Reply To: address as below
Our Ref: 6/2017/2203/COND
Direct Tel: 01707 357211
Fax: 01707 357253
Email: planning@welhat.gov.uk

RE: 6/2017/2203/COND – Submission of details pursuant to condition 3 (Demolition and Construction Method Statement) on Planning application 6/2016/1740/LB dated 13 October 2016 at Ramada Hatfield St Albans Road West Hatfield AL10 9RH.

Condition 3 (Demolition and Construction Method Statement)

Protection Detail

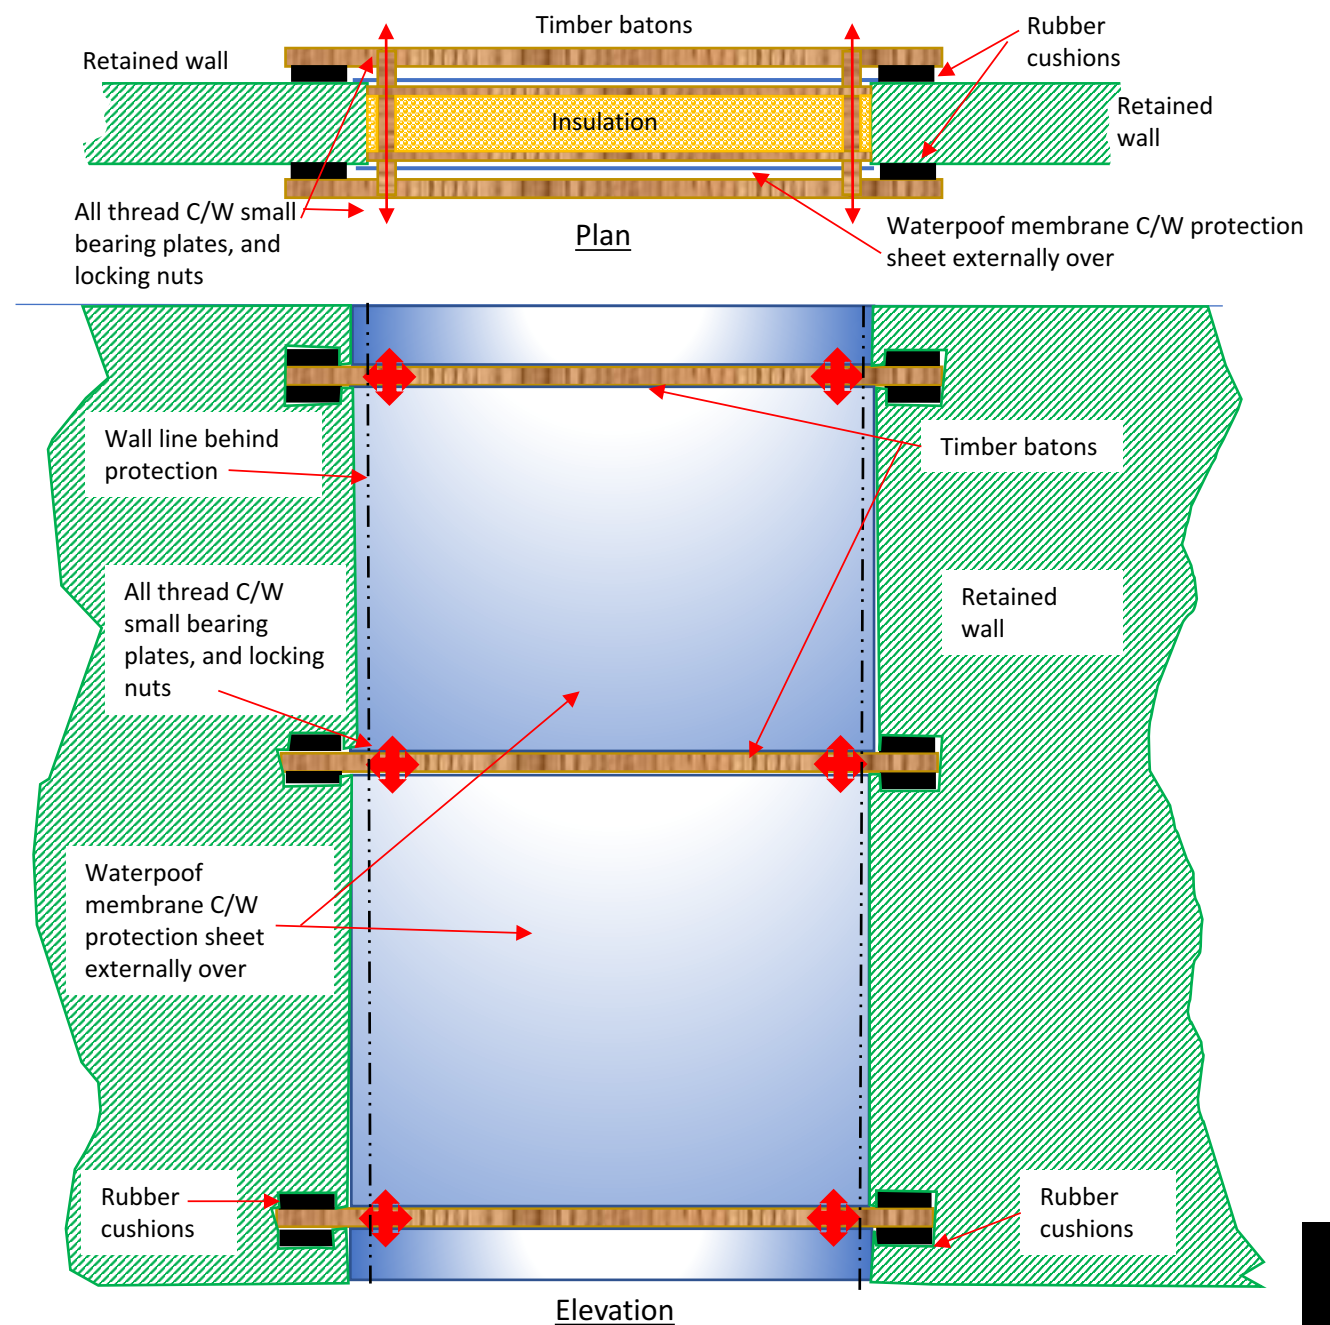
The Heritage Consultee had concerns over the security and protection of the Listed Building following the demolition of the rear extension and the separation cut (referred to as “the approved demolition works”). This has been clarified in the submitted Enabling Works Overview R3 and via emails with yourselves to confirm site security and that the rear door will be solid and covered in waterproof sheeting.

I confirm that these details are acceptable further to Condition 3 to enable the demolition of the rear extension (the approved demolition works) to commence. Please, ensure the demolition is carried out in accordance with these approved details.
